Current Zoning: N1-A (Neighborhood 1-A)
Proposed Zoning: B-1 (CD) (Neighborhood Business, Conditional)

Approximately 3.99 acres located at the intersection of Rhyne Road and Moores Chapel Road.

The petition proposes to develop a vacant property in northwest Charlotte with up to 10,000 square feet of uses permitted in the B-1 zoning district including 16 fuel pumps and a fast food restaurant with drive-through.

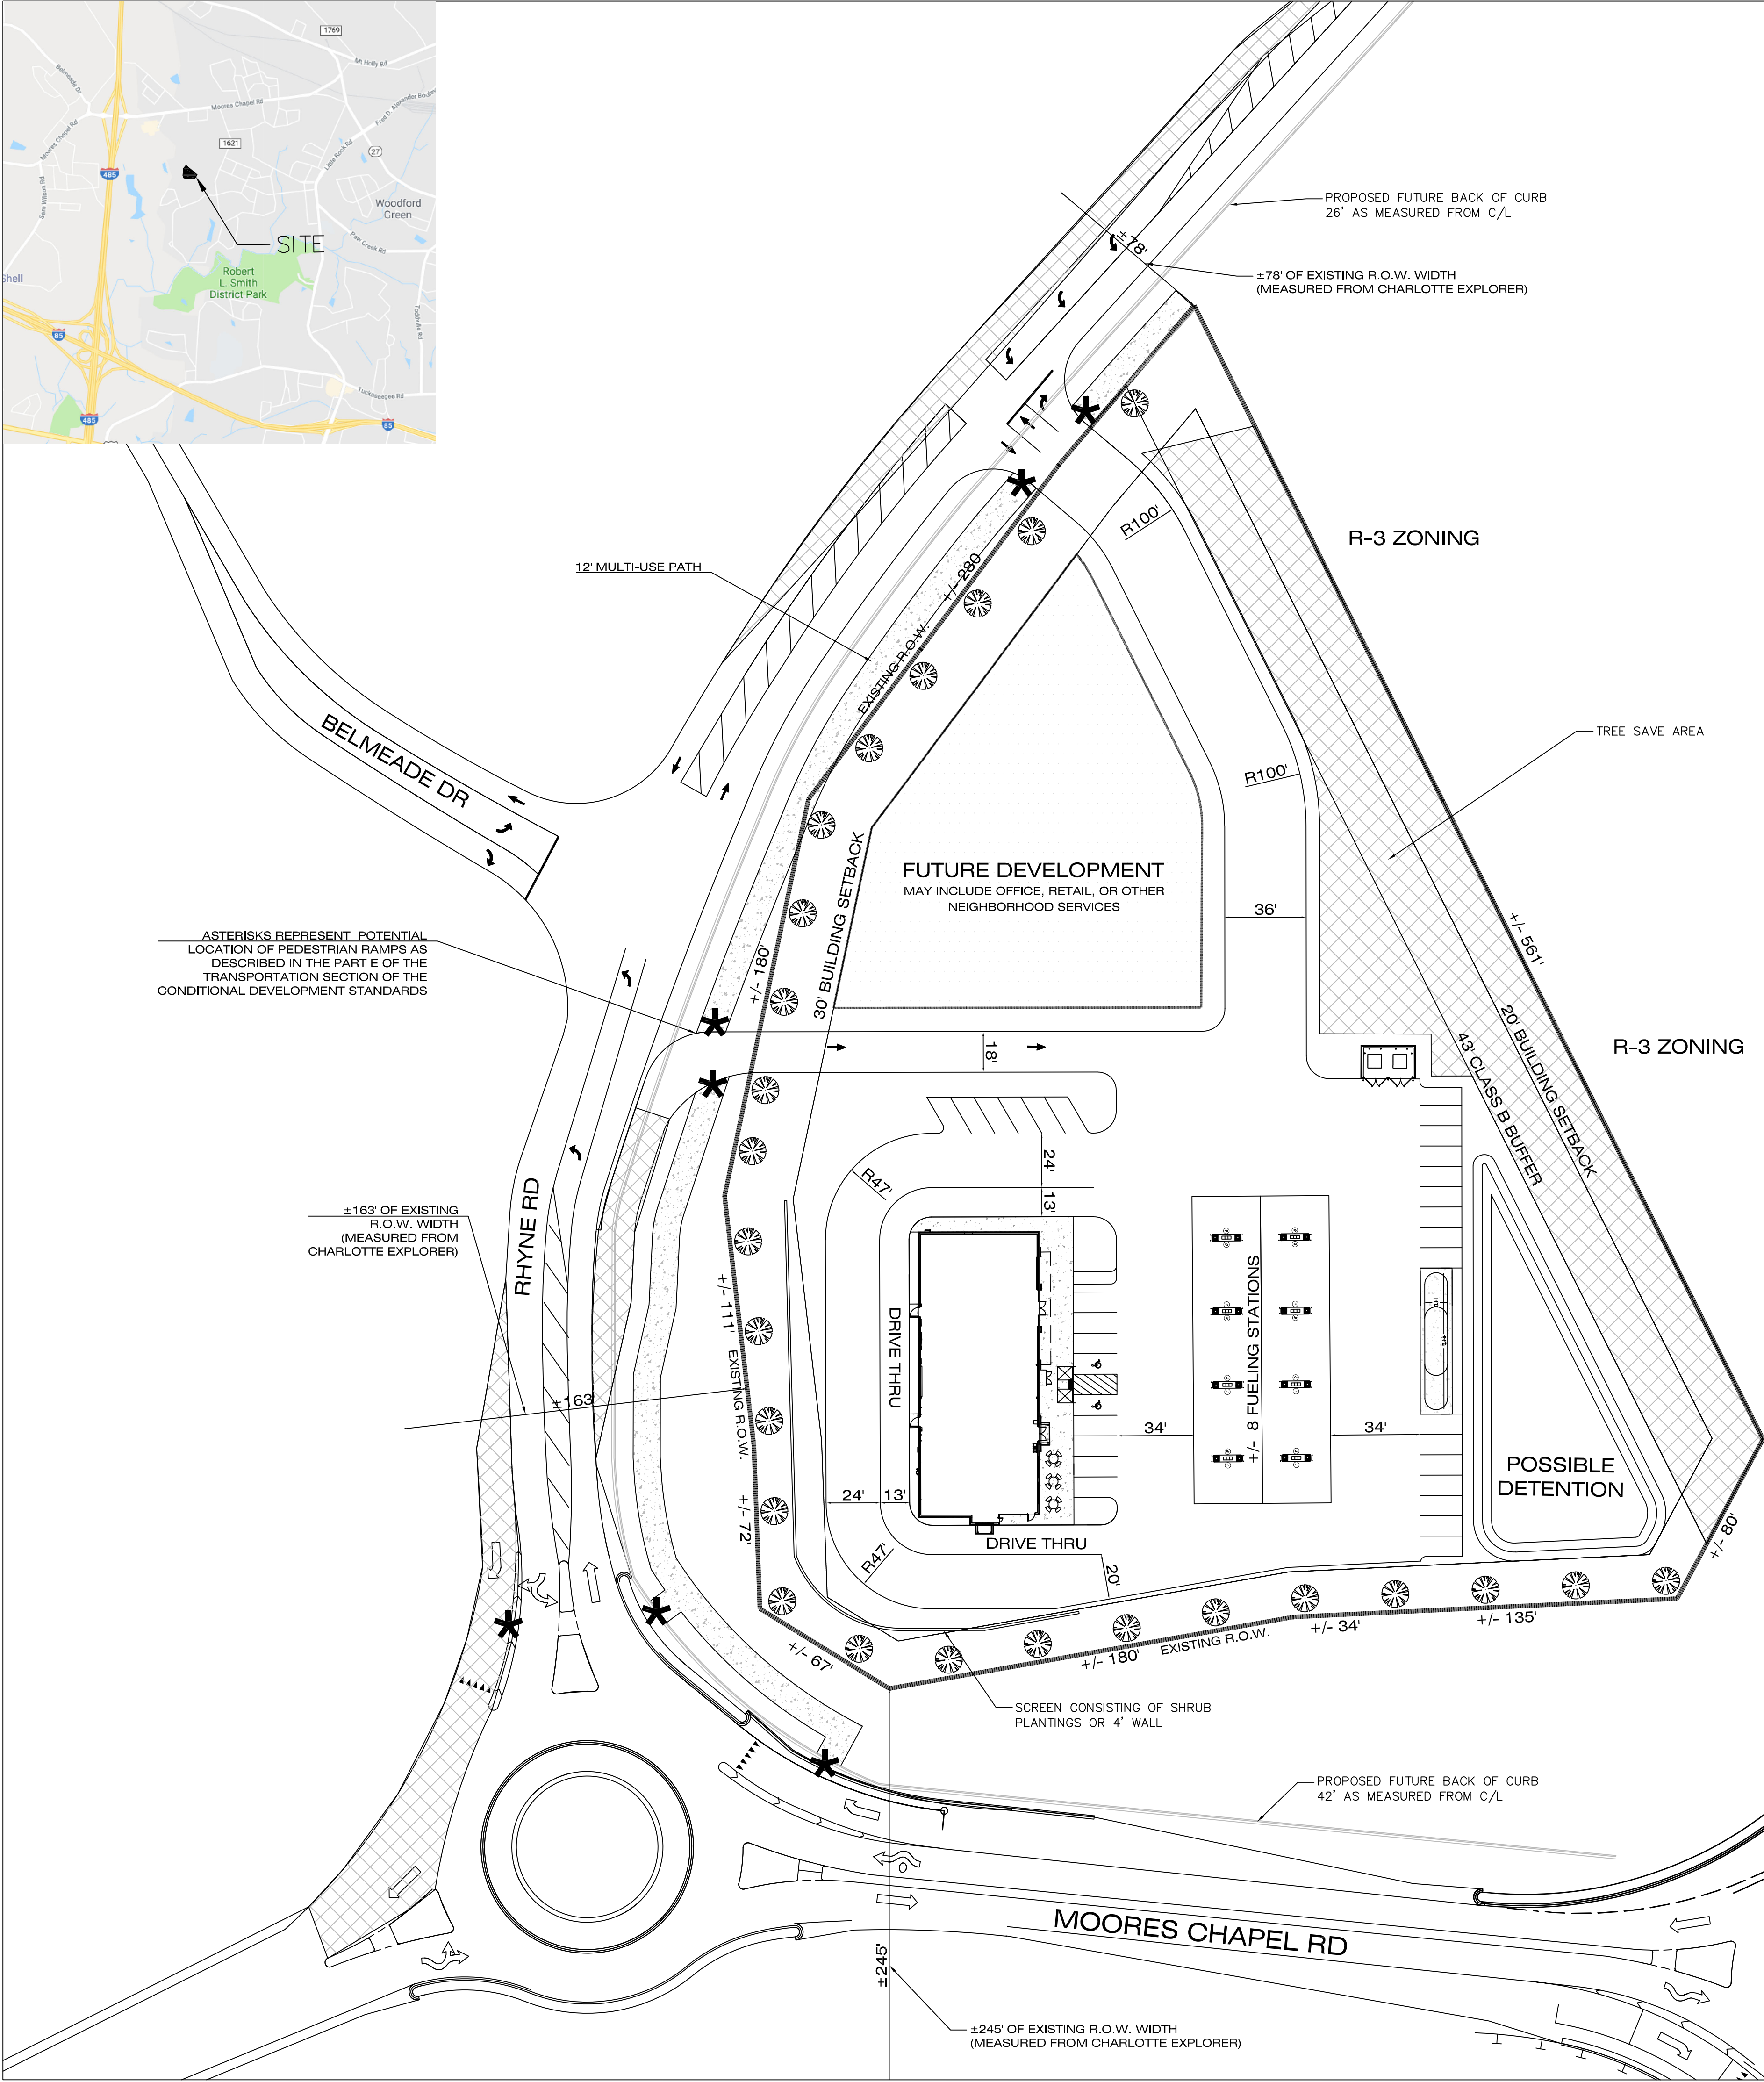
1. Revise site plan and conditional note(s) to provide 12-foot multi-use path and 8-foot planting strip for the remainder of the Moores Chapel Road frontage. Sidewalk facilities are required per City ordinance for all public street frontages. Revise the ramp locations and conditional note Transportation Note E to include the additional ramps that will be required. Provide SUE located 2-feet behind sidewalk if located outside of the ROW. Add conditional note to coordinate Control of Access Break with NCDOT for proposed multi-use path along Moores Chapel Road. **OUTSTANDING**

2. Label and dimension streetscape along all public road frontages (12-foot multi-use path and 8-foot planting strip). Revise ramp locations as shown above and update conditional note to incorporate additional ramps. Provide SUE located 2-feet behind sidewalk if located outside of the ROW. Add conditional note to coordinate Control of Access Break with NCDOT for proposed multi-use path along Moores Chapel Road. **OUTSTANDING**

3. Label, dimension, and commit to curb and gutter and multi-use path in conditional notes. **OUTSTANDING**
4. ~~Add a conditional note specifying that all transportation improvements will be approved and constructed before the site's first building certificate of occupancy is issued as needed. The petitioner may phase transportation improvements if said improvements and phasing are explicitly described in site plan notes. **ADDRESSED**~~
